**Comments on Other Submissions
(submitted at Deadline 5)
for the
Royal Society for the Protection of Birds
and Suffolk Wildlife Trust**

**Submitted for Deadline 6
6 August 2021**

**Application by NNB Generation Company (SZC) Limited for an Order
Granting Development Consent for
The Sizewell C Project**

**Planning Inspectorate Ref: EN010012
RSPB Registration Identification Ref: 20026628
Suffolk Wildlife Trust Registration Identification Ref: 20026359**

DRAWING TITLE:
MAIN DEVELOPMENT SITE SSSI CROSSING
(UNDER CONSTRUCTION - BAILEY BRIDGE STAGE)

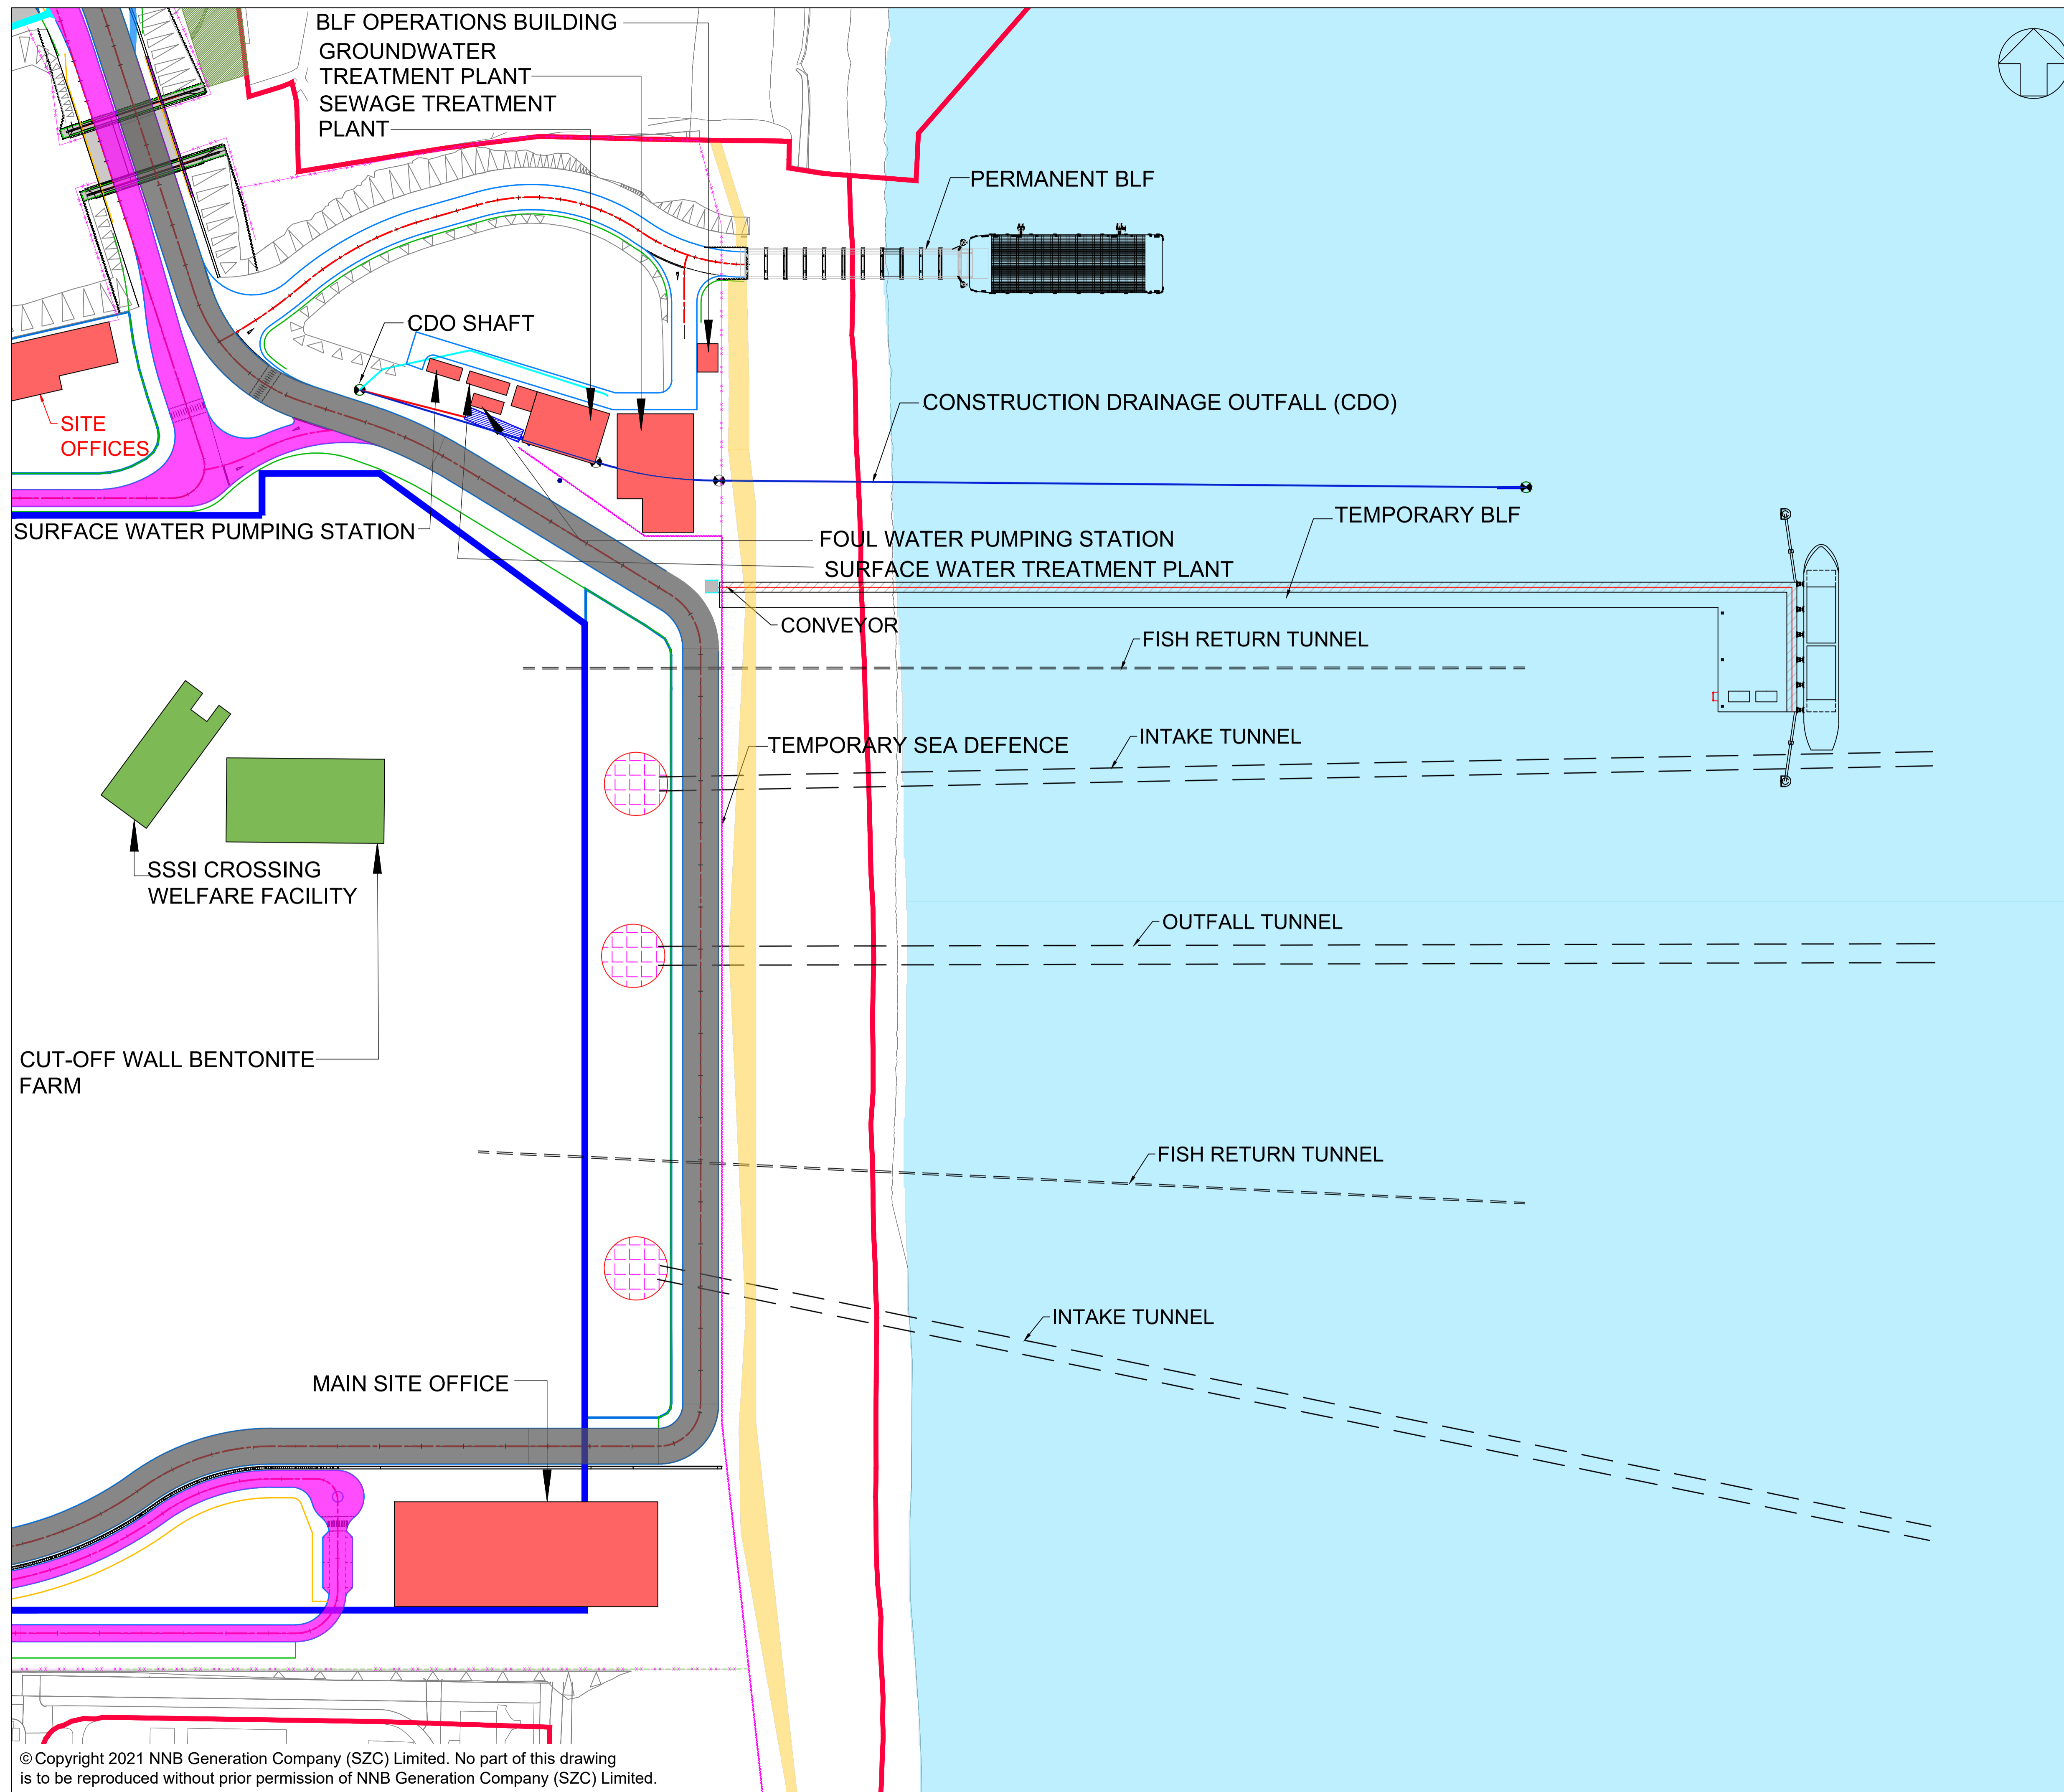
2.1. We provide comments on the updated SSSI Crossing Plans¹⁸. We welcome the increased height and the reduced operational width to improve ecological connectivity. We do still consider a 3 span bridge would be the preferred crossing option to minimise SSSI land take and habitat fragmentation. We note the plans are not for approval and query how they will be secured?
